# Redlands Senior Campus Master Plan: 2015 & beyond

## Additional Consultation

A number of residents of 19 Waters Road provided submissions to the Department of Planning and Environment objecting to elements of the Master Plan. Key concerns related specifically to Stage 4 of the proposal, in particular perceived impacts relating to the built form and operation of the Stage 4 Humphery Learning Hub.

**Meeting date:** 24 September 2015

NEW HUMPHERY LEARNING HUB - STAGE 4

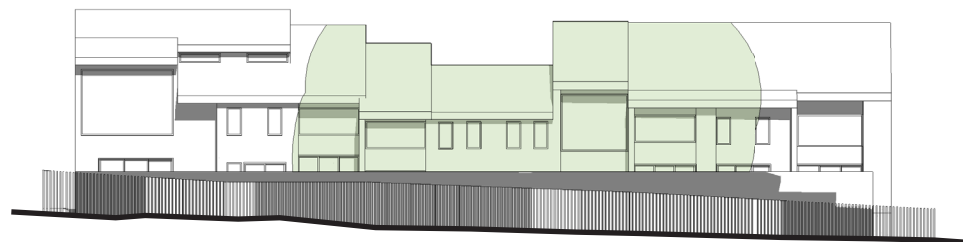
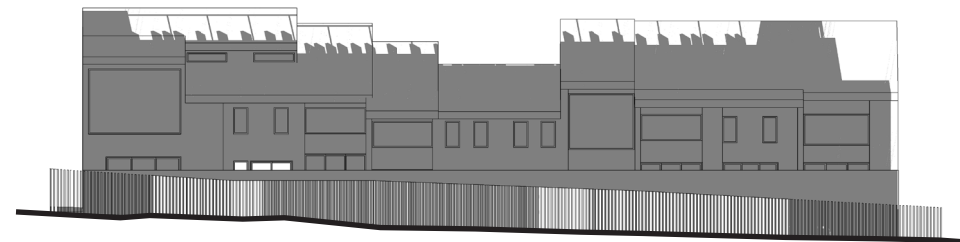
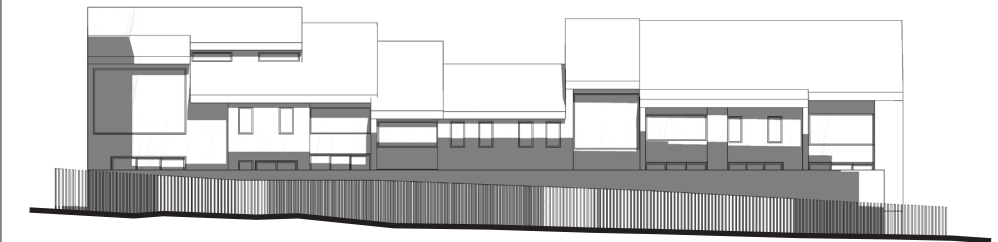
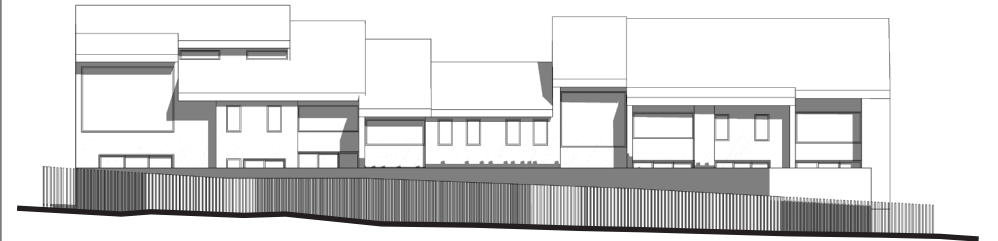
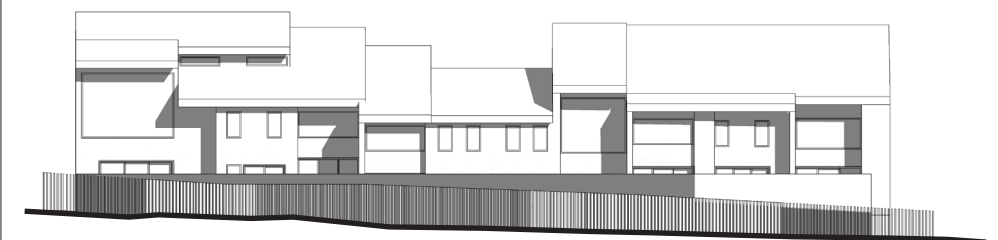
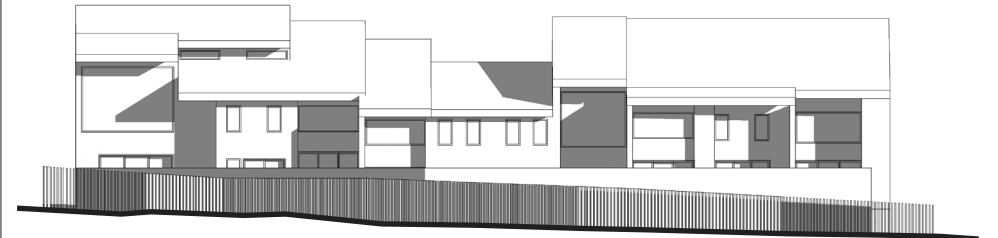
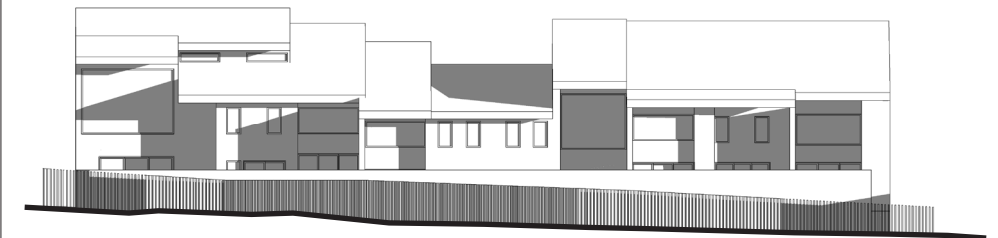
- » Concerns about the operational use of the area directly behind the residences of 19 Waters Road for school bus pick up and drop offs and waste collection
- » Continued privacy and overshadowing concerns
- » Concerns around height compliance
- » A request for additional information regarding overshadowing (earlier in the morning and later in the afternoon) and operating conditions for buses and garbage pick up

Residents requested that Redlands provide updated shadow impact assessments, directly comparable to the times/images provided in the original submission, with the Outcomes Report.
